Your Ref: OWPC16787
Our Ref: M/123/17/HH 21-11-2017
Please ask for:
Mrs A Gardner

3rd January 2018

Two storey extension to existing building. Re-submission of M/71/17/HH
Little Thatch 93 Middleton Road Middleton on Sea

EXTENSION & ALTERATIONS

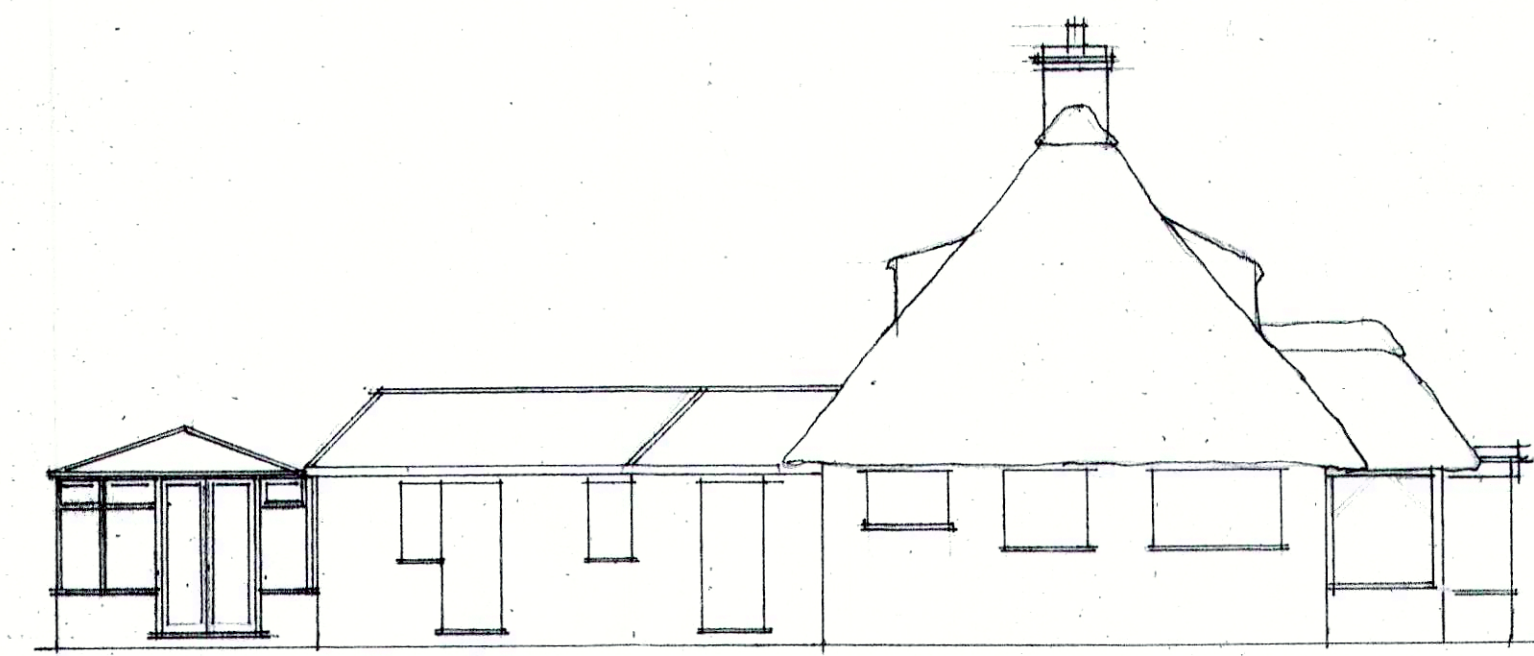
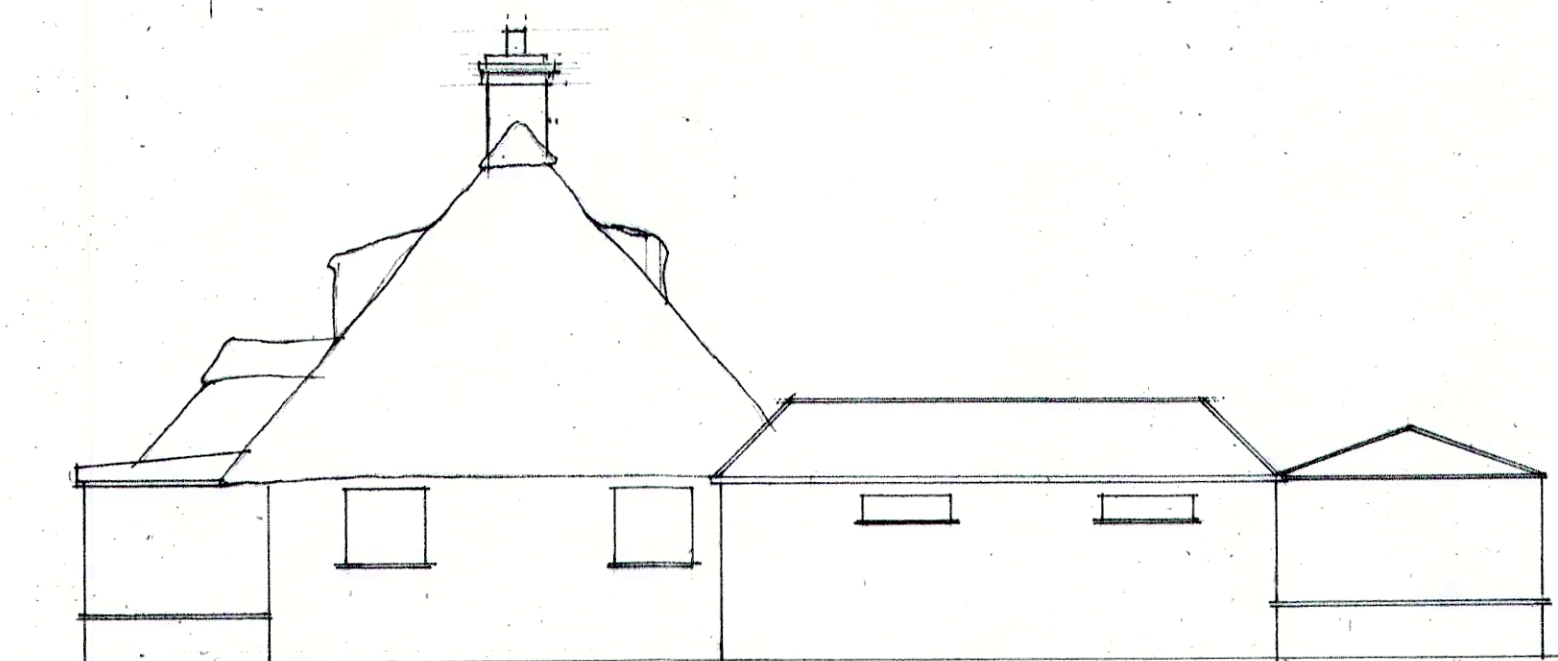
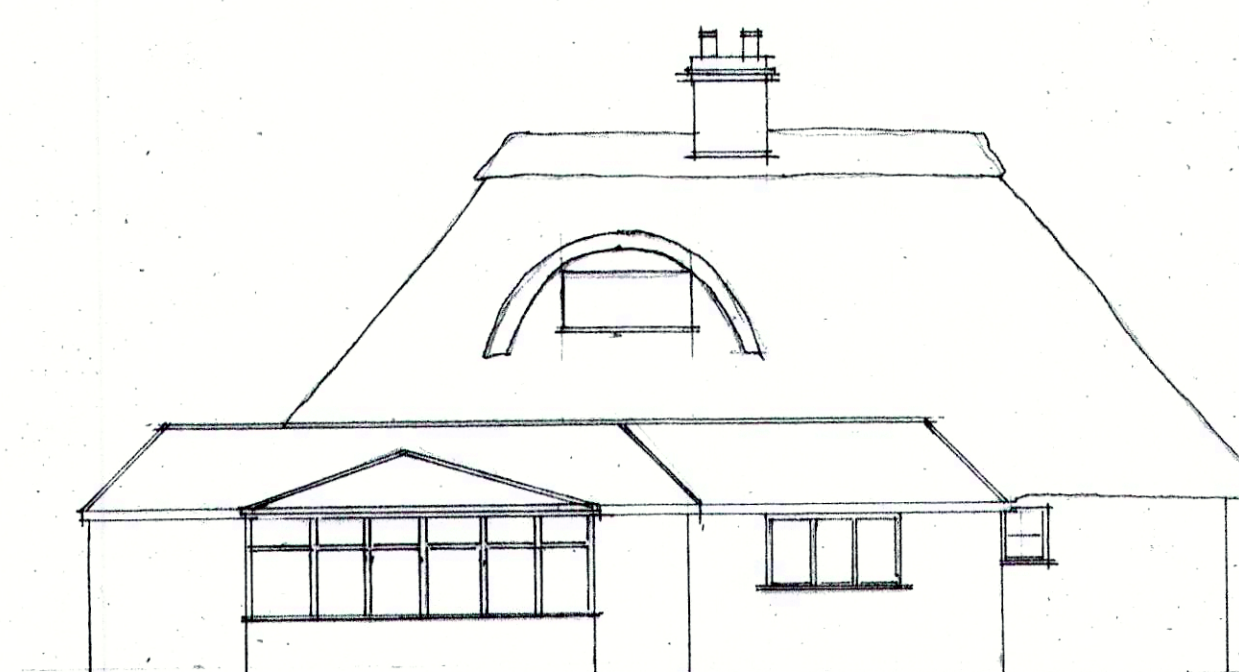
*I have concerns about the overall height of the proposed building and how this will impact on neighbouring properties.
I would be grateful if consideration could be made to the fact that we are a bungalow and have both living and sleeping accommodation facing the proposed property.
Of further concern is the siting of the building plot close to the East and South boundaries rather than centrally which would be less imposing.*
